**Application No:** 20/00634/DISC

**Proposal:** Discharge of Condition 15 (Car Park Management Plan) of 18/00513/REM-Village Centre North

**Location:** Heyford Park Camp Road Upper Heyford

## **Transport Development Control**

Figure 1-1 - Village Centre North and Phase 1 Village Centre South Layout Plan

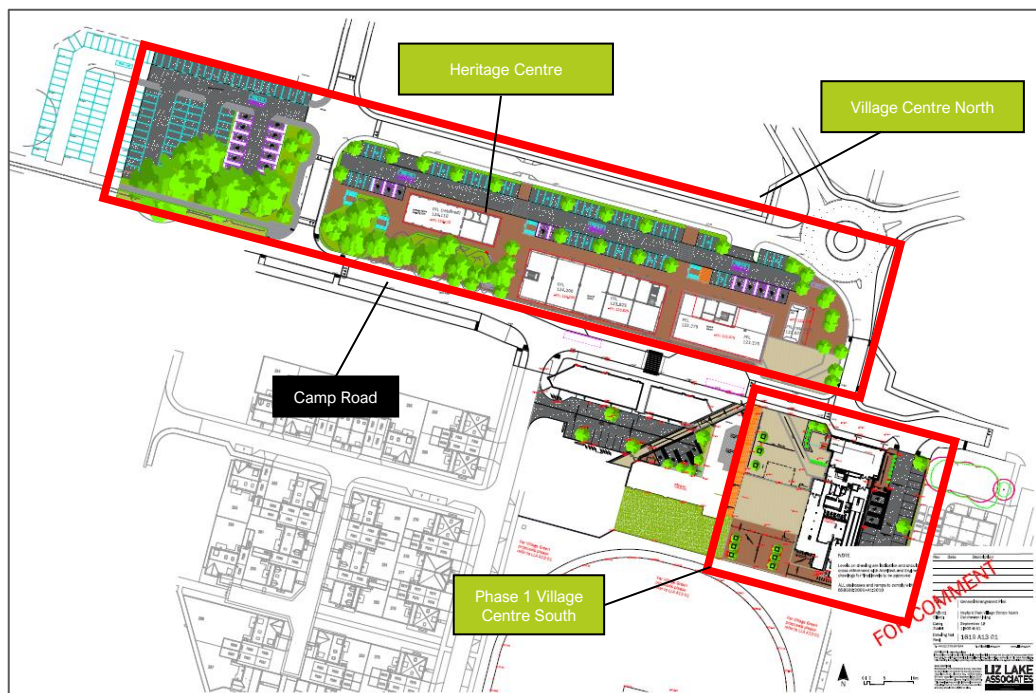
- Paragraph 1.1.1 states that this application is in discharge of a condition of planning permission 18/00043/NMA, whereas it is actually in discharge of planning permission 16/01000/F.
- Figure 1-1 would benefit from showing the Heritage Centre as well since the CPMP covers this facility. **Reason for objection.**
- Paragraph 1.2.1 states that the jurisdiction of the CPMP is “*North and South sections of Village Centre*” this would benefit from being clarified as “*...as shown in Figure 1-1*”
- Paragraph 1.3.2 states that “*this CPMP will come into effect once the Village Centre North external works are completed prior to the rest of the Village Centre North opening.*” It is not clear why Village Centre North is the trigger for the CPMP to come into effect.
- Paragraph 3.1.2 makes no reference to the Heritage Centre.

Figure 3-3 - Car Parking Allocation

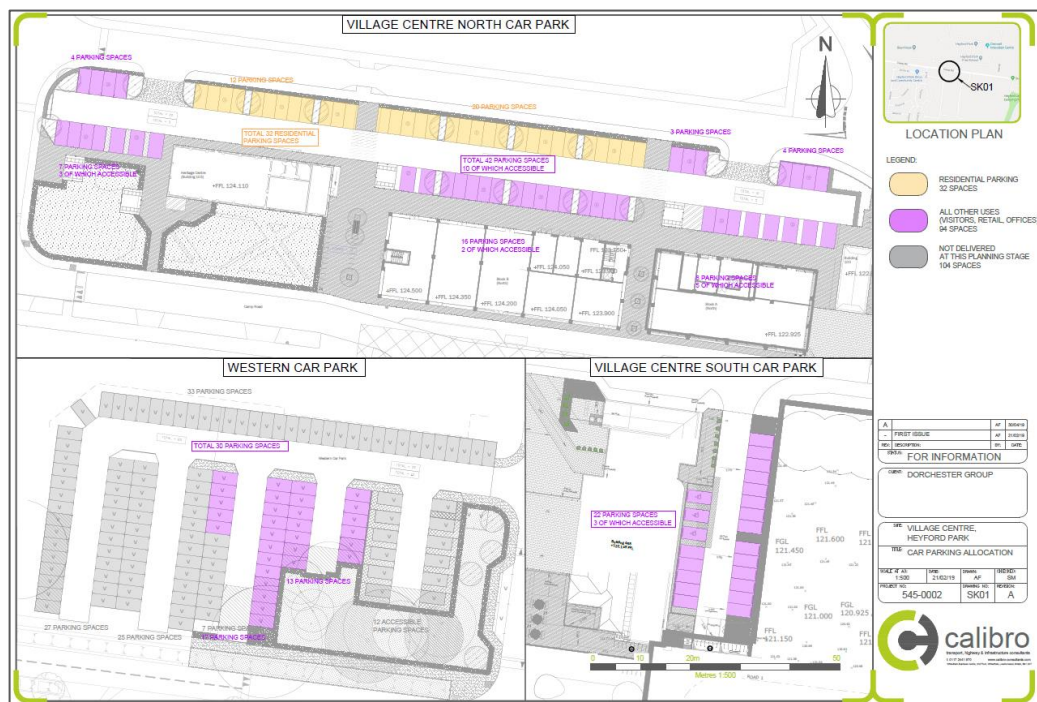
- Figure 3-3 appears to show a total allocation of some 126 car parking spaces. It is assumed that these include spaces to serve the heritage centre, although it is not clear how many. The County requires a clear statement of how many parking spaces are managed by this CPMP, and the use for which they are intended. As noted above the total number of car parking spaces will need to provide for occasions when the accumulated demand for non-residential uses will be exceeded. **Reason for objection.**
